COMMUNITY SERVICES DEPARTMENT
PARK OPERATIONS ~ ENVIRONMENTAL SERVICES ~ RECREATION/CULTURAL SERVICES

Subject: Mayberry Filing No.3 Final Plat (SF-2219)

The Community Services Department has reviewed the development application for Mayberry Filing No.3 Final Plat and is providing the following final comments on behalf of El Paso County Parks.

OVERALL LAYOUT OF THIS REPLAT

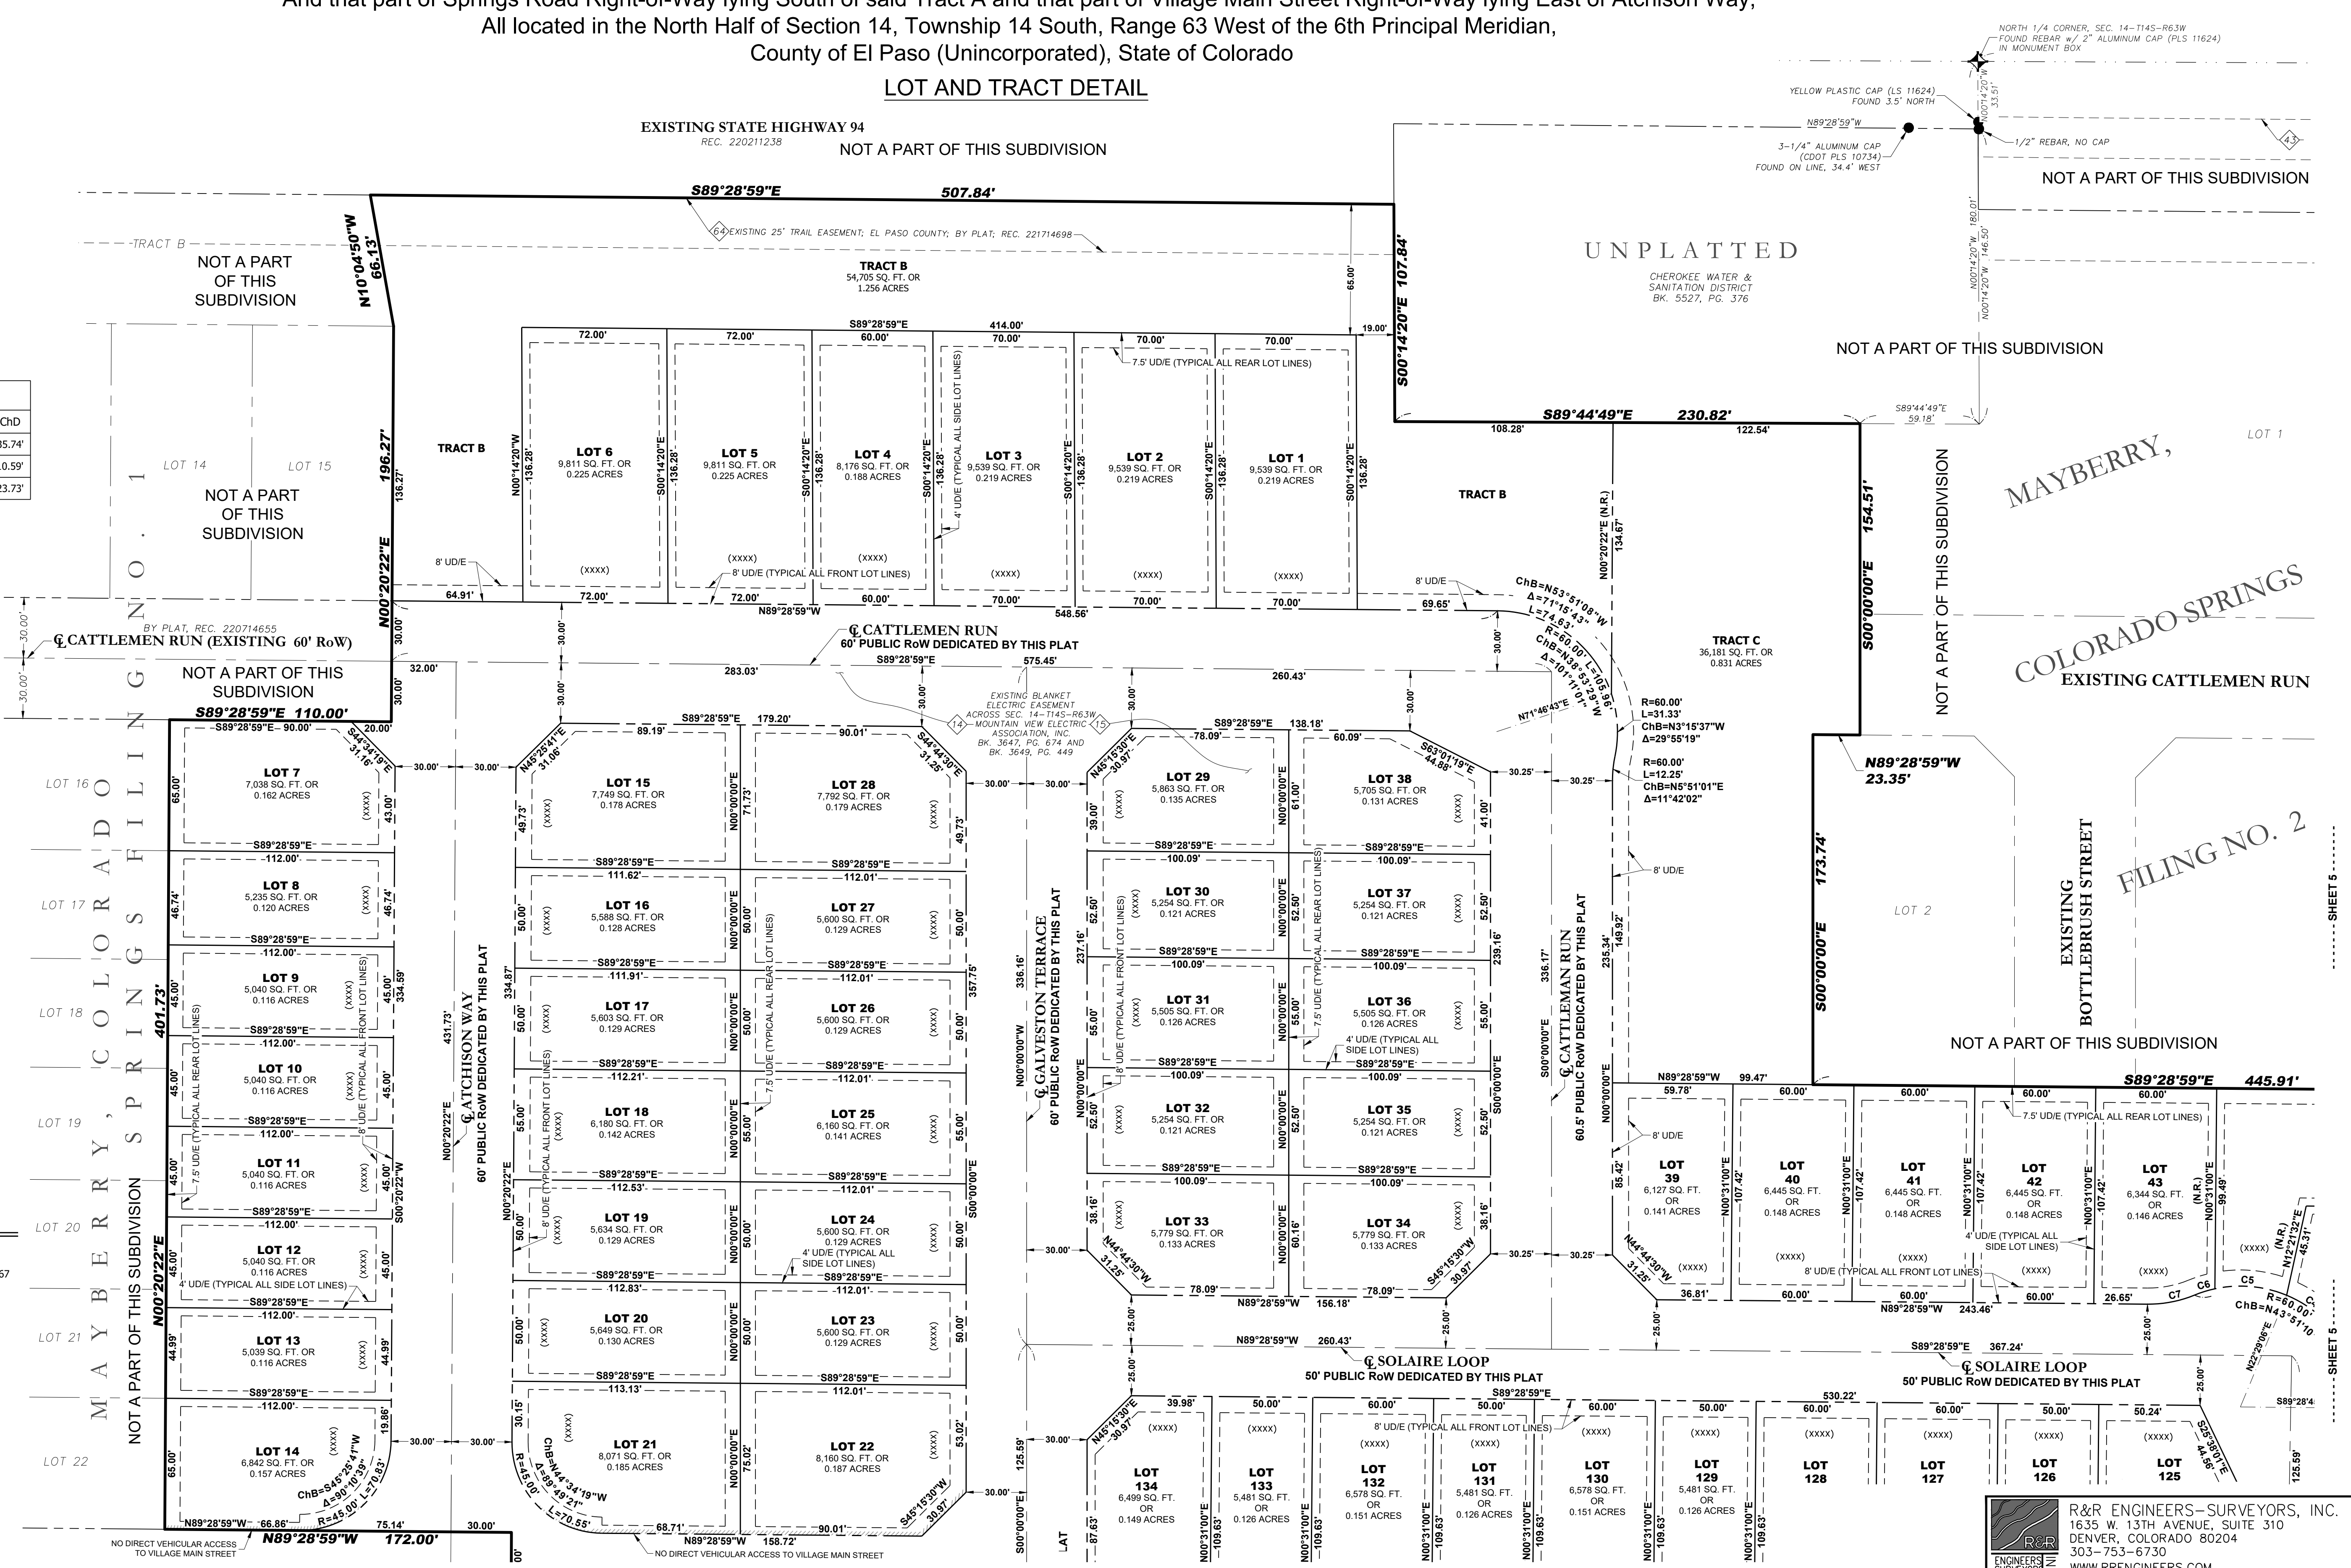
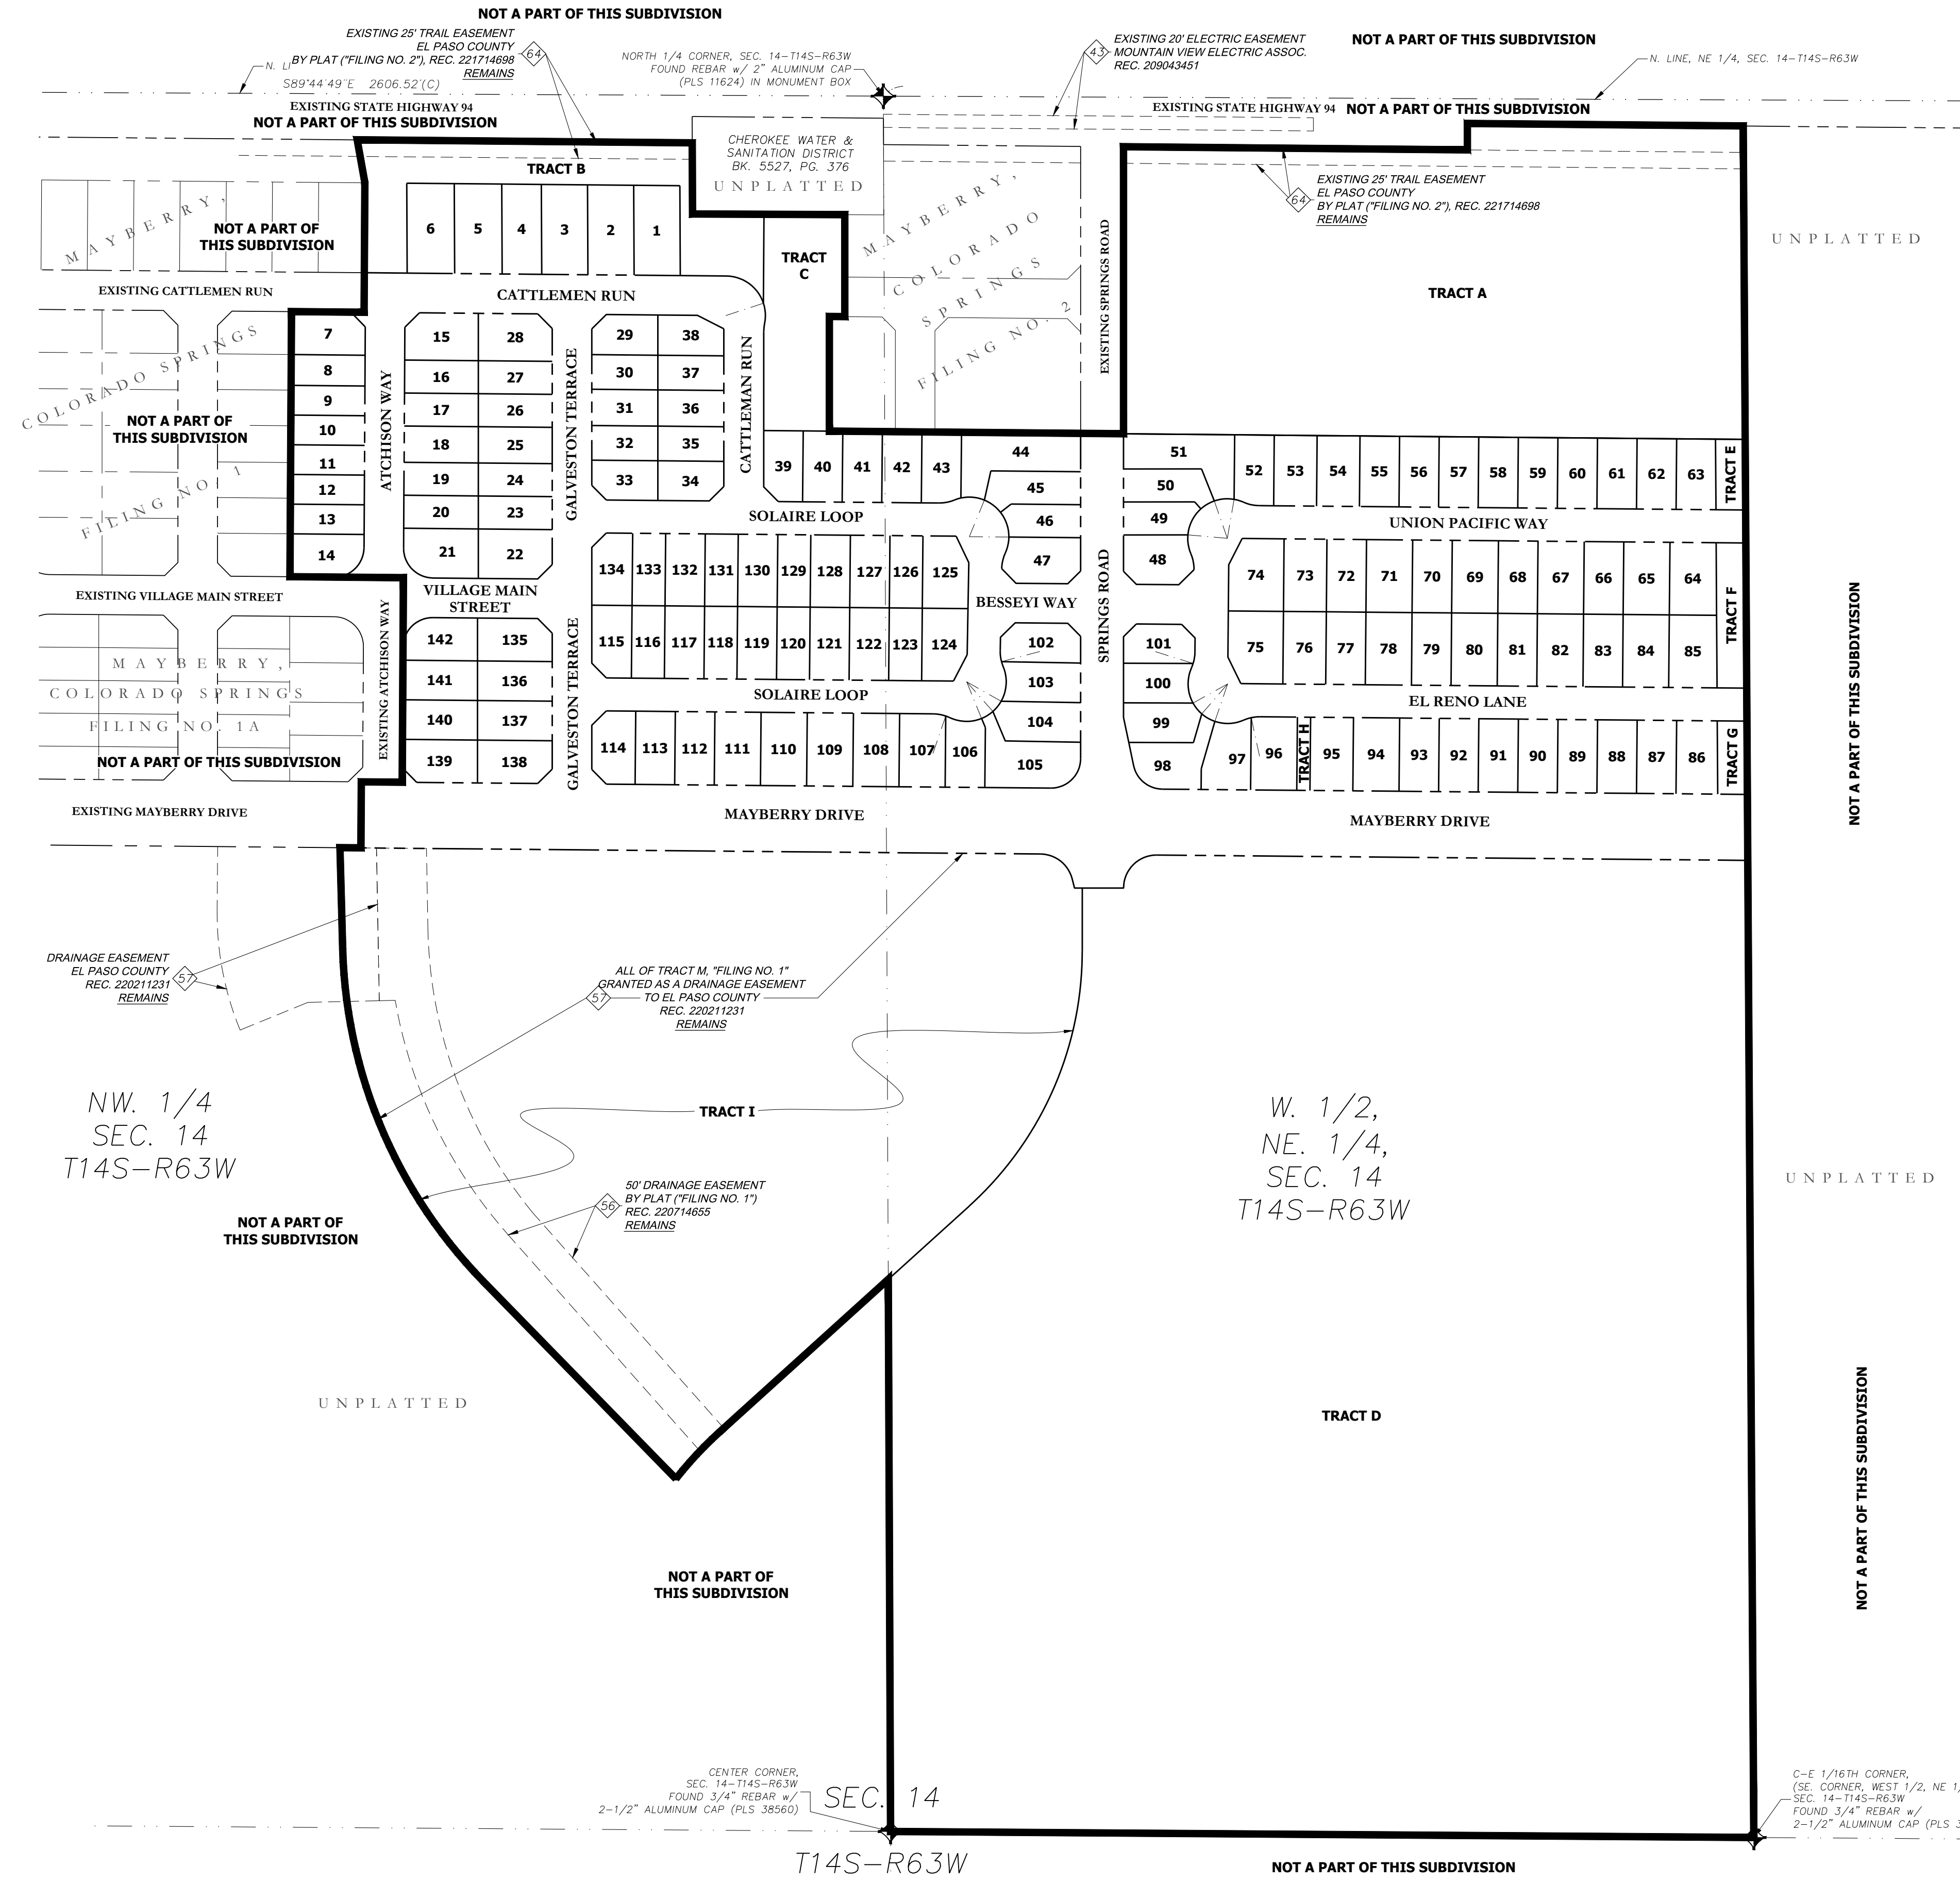
County Parks requests trail easements where development projects impact proposed County trails. As it pertains to this application, the County requests that the landowner provide a 25-foot public trail easement along the south side of Highway 94 that allows for the construction and maintenance by El Paso County of a Secondary Regional Trail, and this easement shall be shown and dedicated to El Paso County on the Final Plat. The trail easement is shown on the Filing No.3 Final Plat as "Existing 25' Trail Easement El Paso County by Plat (Filing No.2) REC. 221714698 Remains."

Recommend that the Planning Commission and the Board of County Commissioners include the following conditions when considering and/or approving the Mayberry Filing No.3 Final Plat: (1) require fees in lieu of land dedication for regional park purposes in the amount of \$65,320, and urban park fees in the amount of \$41,180. (2) provide a 25-foot public trail easement along the south side of Highway 94 that allows for the construction and maintenance by El Paso County of a Secondary Regional Trail, and this easement shall be shown and dedicated to El Paso County on the Final Plat.
